Development Facilitation Team (DFT) – Review Comments

Project No: PR-2024-011129 **Date:** 6/11/2025 **Agenda Item:** #12 **Zone Atlas Page:** B-20

Location: 9001 Modesto Ave NE

Application For: – VA-2024-00313 – SIKEWALK WAIVER

(IN FEET)
1 inch = 50 ft.

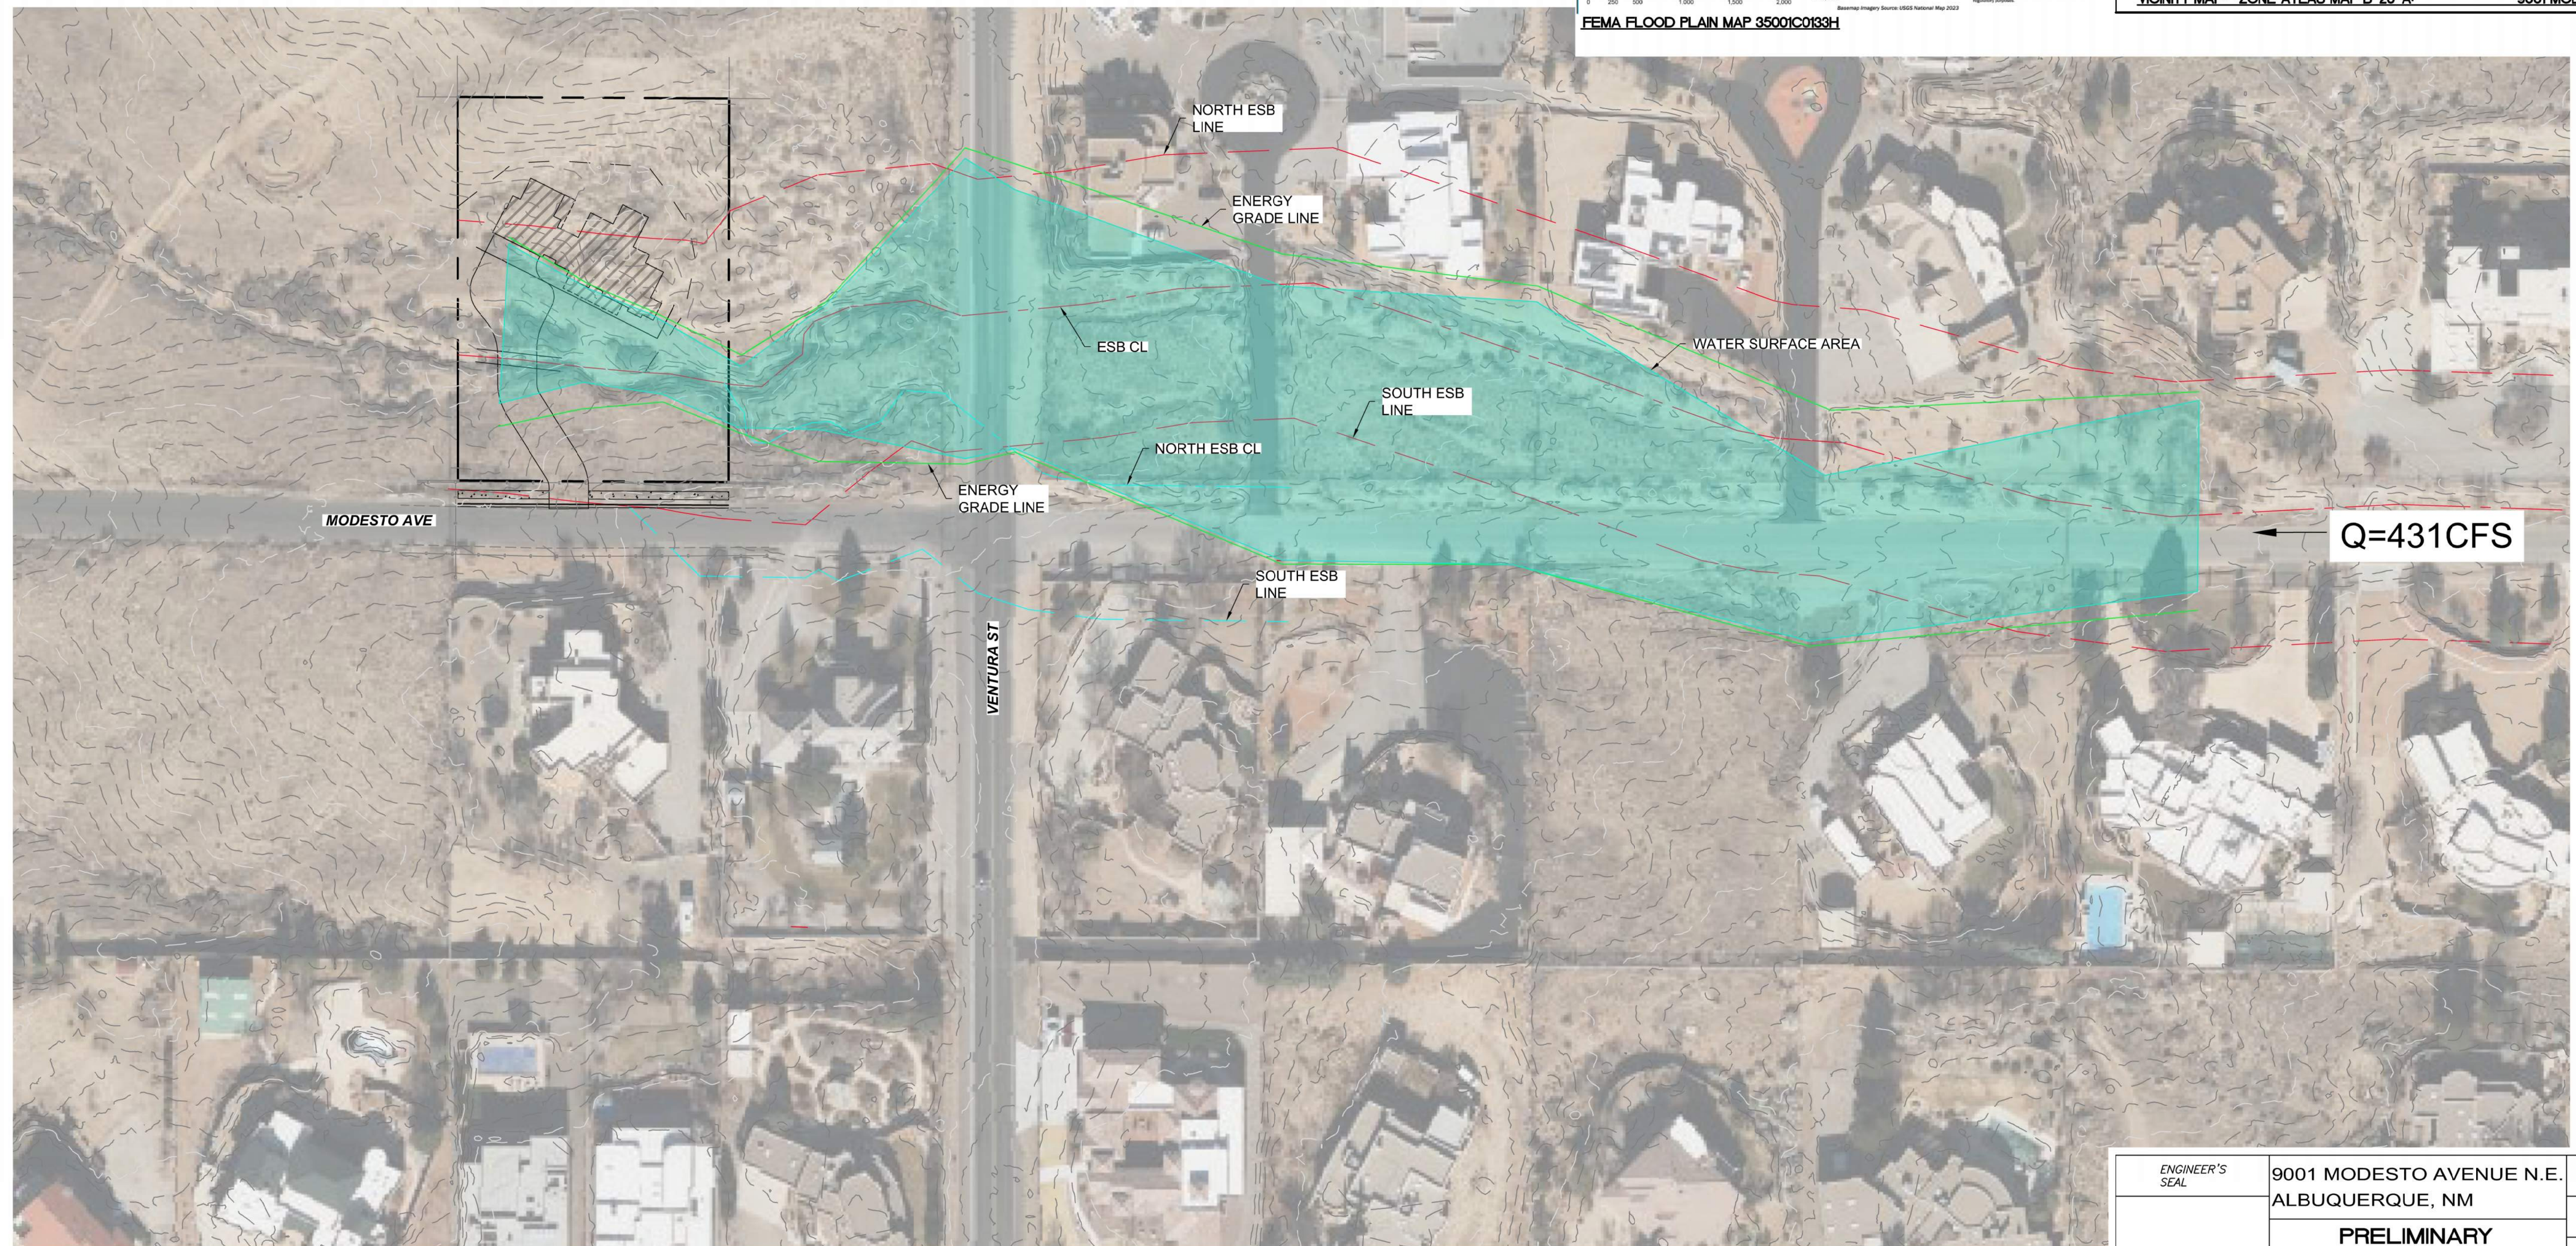
- Hydrology objects to the Sidewalk Waiver action due to essential roadway curb, gutter, and sidewalk improvements needed to mitigate or prevent adverse effects from stormwater drainage or runoff onsite and/or in the public R/W.
- Prior to submitting for a Grading Permit or a Building Permit for any site upgrades, a licensed New Mexico civil engineer will need to submit a Grading & Drainage Plan to Hydrology for review & approval if one of these conditions is met: (500 cy of grading, 1,000 sf of proposed building, or 10,000 sf of proposed paving).

6-6(P)(3)(1)(a)(1)c. The arroyo mentioned flows ~70' north of the roadway through the property and would not be impacted by the addition of the sidewalk, curb and gutter. The drainage master plan calls for storm drain to be installed in the intersection of Ventura and Modesto and routed north to Glendale which will cut off most of the flows west of the intersection. The new supplemental submittal with building permits listed without financial guarantees for curb, gutter and sidewalk do not represent what the applicant hoped. 2 of the 7 were permits for interior alterations and generated no site plans for review, 3 were additions smaller than 1000 sf so no new G&D's required (so no review of sites by DRS), 1 shows an incorrect address (8600 Modesto when permit is for 8527 Modesto) has sidewalk and 1 was the Florence address has a waiver approved by the applicant which was strongly opposed by Transportation. The only reason an appeal was not made on this case was that there was an ordinance change working through City Council at the time that would assess fronting properties for infrastructure improvements which would have made the waiver moot. The ordinance did not pass council.

6-6(P)(3)(1)(a)(2). The claim that City would be required to install storm drain if the waiver is not allowed is not supported by evidence and is contrary to City Hydrology.
